**Application reference:** 6/2020/1088/HOUSE

**Proposed development at** 83 Bramble Road, Hatfield, Herts, AL10 9SB

**Proposal:** Erection of outbuilding

Block plan:
1:500

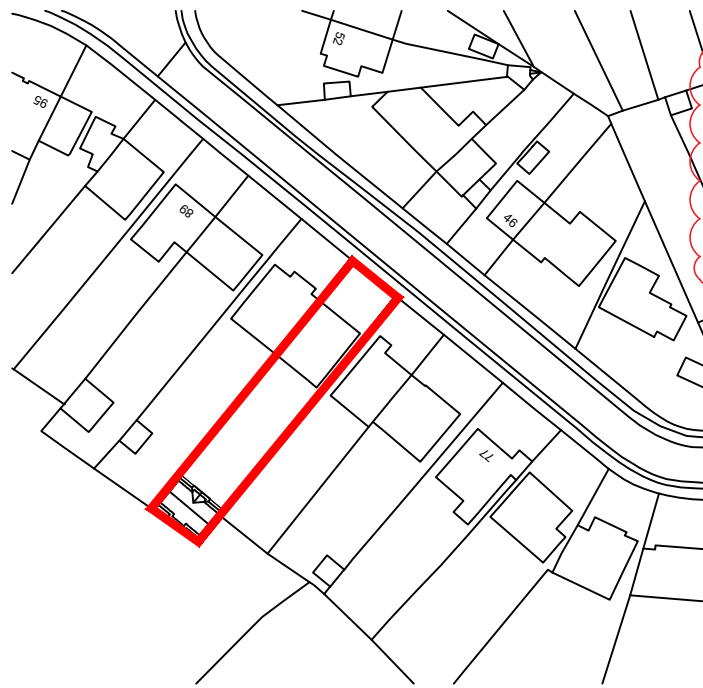
The size of the building is not proportionate to the garden and sits extremely close to our fence as well as the fence adjacent to 85 Bramble Road. We are concerned that the building is constructed entirely of combustible materials.

Rev.	Amendment	Date
title Single storey garden outbuilding		
drawing AS BUILT Elevations		
job 85 Bramble road		client Mr & Mrs Lane
date May 2020	scale 1:100@A3	drawn by PP 03.05.20
drawn by  asq developments - herts 14 Old rectory drive, Hatfield, Herts, AL10 8AF T: 01707 261927 M: 07894 761012

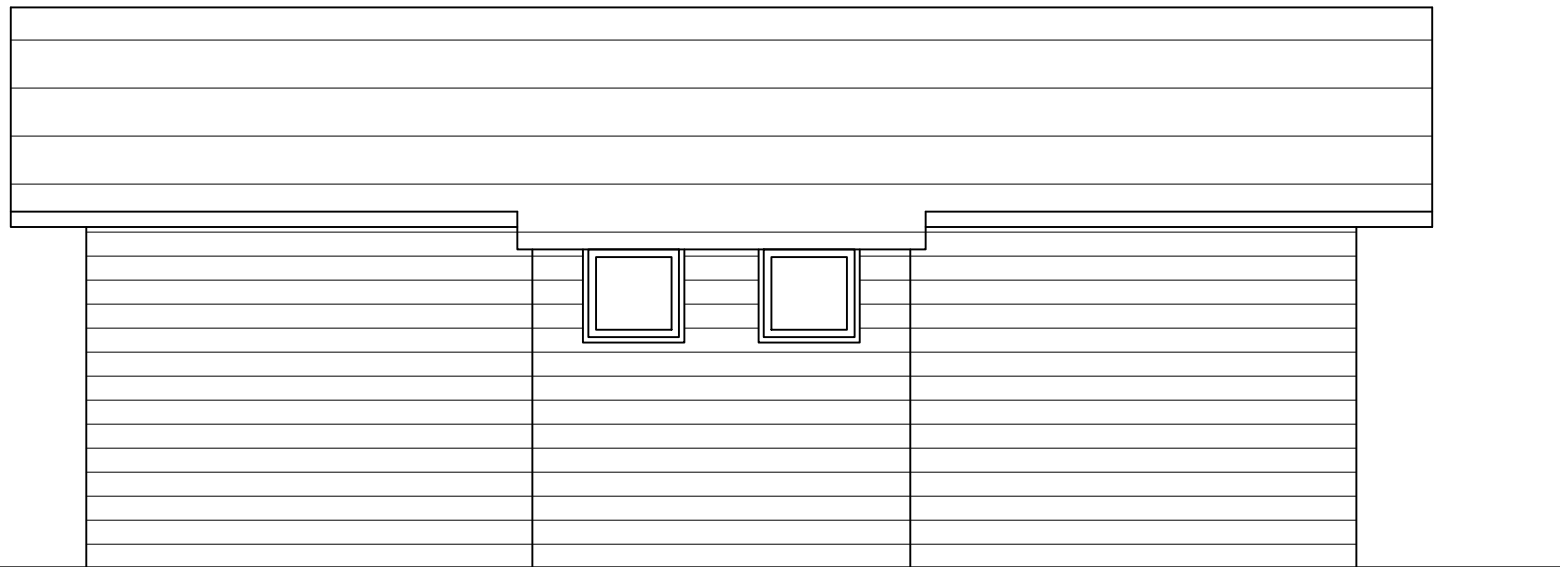
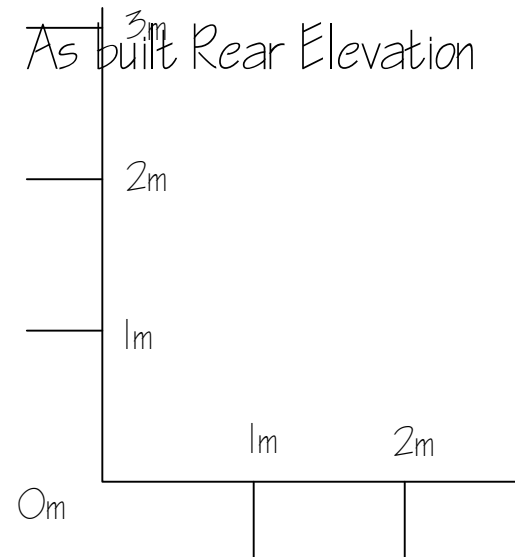
In addition, the size and scale of the erected building at approximately 40m<sup>2</sup> with almost 4m high roof, means that it is feasible it could be used for an independent dwelling. We would request the imposition of a planning restriction that it cannot be used as an independent dwelling.

Rev.	Amendment	Date
title Single storey garden outbuilding		
drawing Proposed Elevations		
job 85 Bramble road		client Mr & Mrs Lane
date May 2020	scale 1:100@A3	drawn by PD 12.05.20
drawn by  anig developments - herts 14 Old rectory drive, Hatfield, Herts, AL10 8AF T: 01707 261927 M: 07894 761012

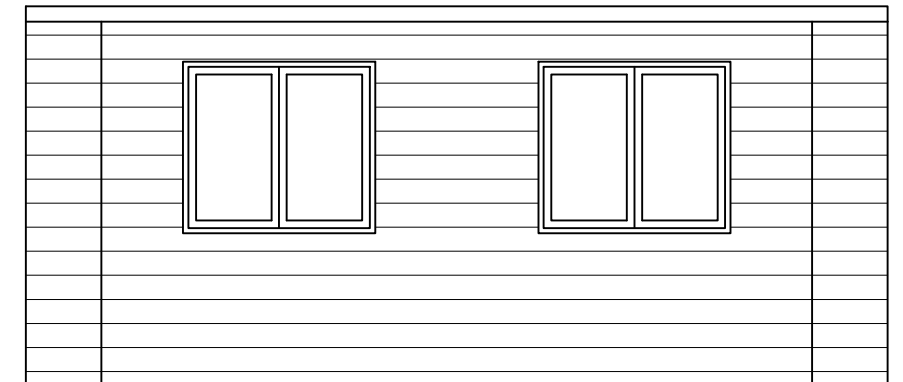
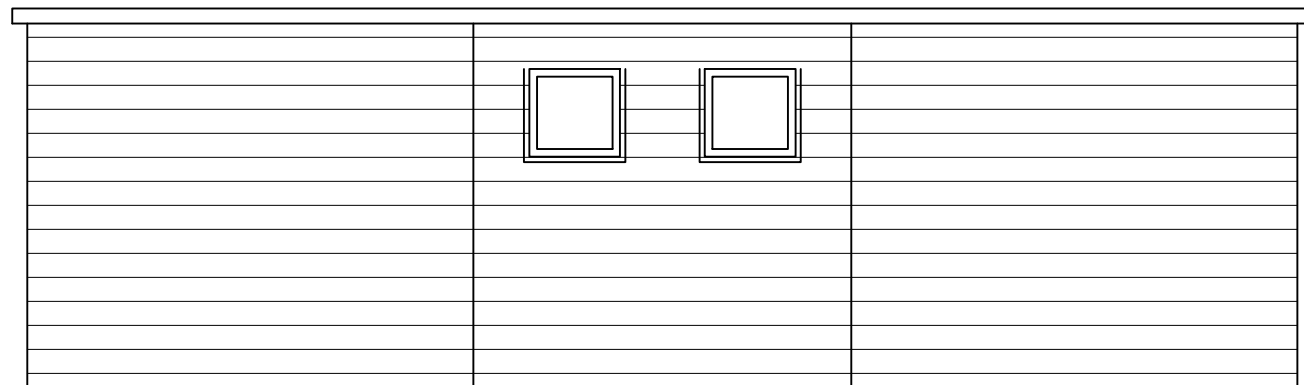
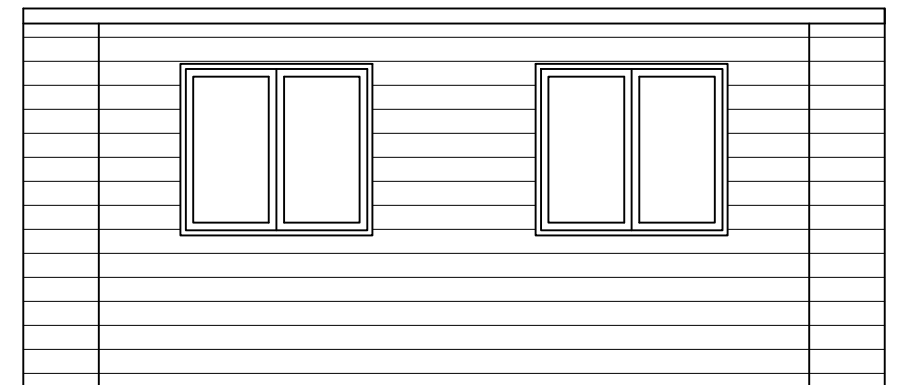
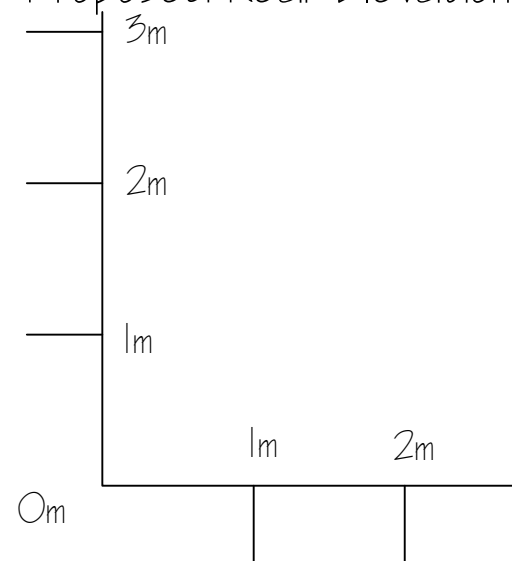
The applicants' son, who has erected this outbuilding, has subsequently stated to us that he intends to change the roof to a flat roof to a 2.4m maximum height. This would go some way to mitigating one of our major concerns which is the impact to our views, but it would still affect the personal enjoyment of our home and garden. As this has not been amended on the application, we would request your consideration on this point should planning permission be granted.
